Application No: LU/315/21/PL
Site Address: 12 Cornwall Road Littlehampton BN17 6EE
Description of works: Change of use from (C3) Dwelling house to 7 bed House in Multiple Occupation (Sui Generis) including the demolition of the existing garage and erection of single storey side extension (resubmission following LU/240/21/PL). This site is in CIL Zone 4 and is CIL Liable as a House in Multiple Occupation.

Thank you for your internet representation made on 20th December 2021 which has been recorded as an objection with the comments as follows:

Block and Location plan

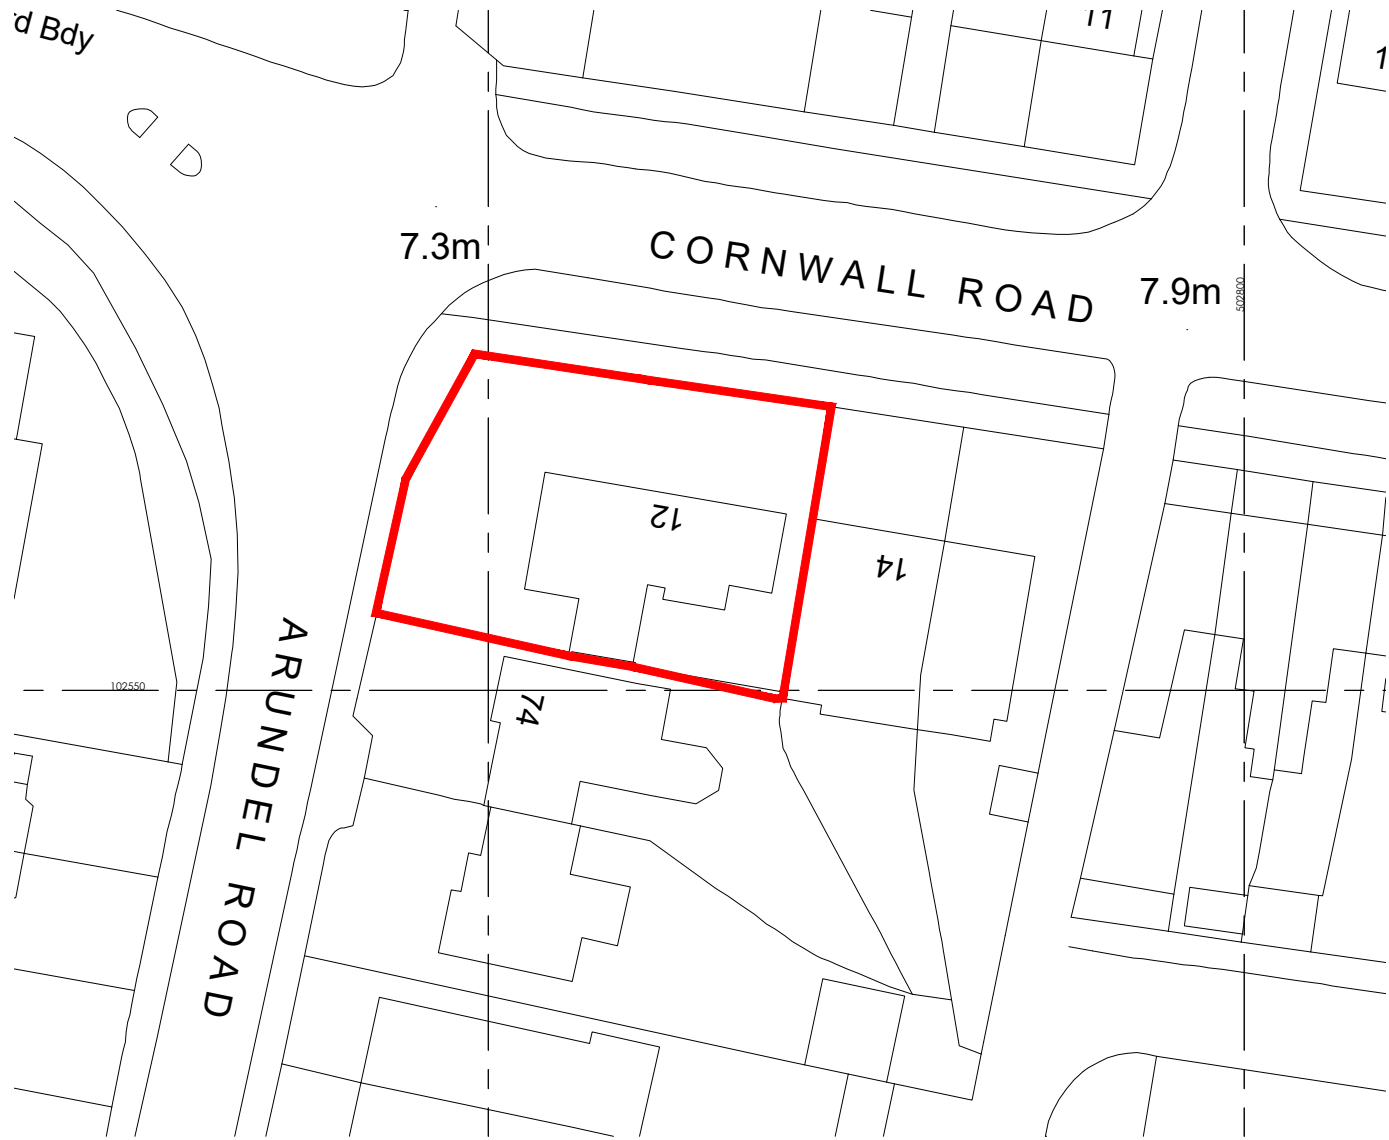
I notice from the revised site plan submitted on 15 December 2021 that there is now a sudden provision for 3 additional car parking spaces at the rear (was garden area) of the property. The original application provided for 2 visitor spaces plus racks for 8 bicycle parking spaces. I wonder if it was always the plan to add these 3 spaces very late in the day (the application being due to be discussed at committee in early January) to circumvent comments submitted about obviously inadequate facilities to cope with additional vehicular prediction for the residents of the HMO and visitors. I cannot understand how the vehicles parked in the 3 additional spaces will be able to manoeuvre out of the plot as I don't see that they will be able to turn round without either significant shuffling in the space available or having to reverse all along the side of the building and across the front of it to reverse out of the driveway. Also if there is already a visitor's (or resident's) vehicle parked in the bay on the front corner of the site, it would make negotiating the corner turn difficult. I have only been driving for 40 years so would welcome comments from Planning officers with possibly greater driving experience than mine regarding the issue of moving vehicles around the plot.
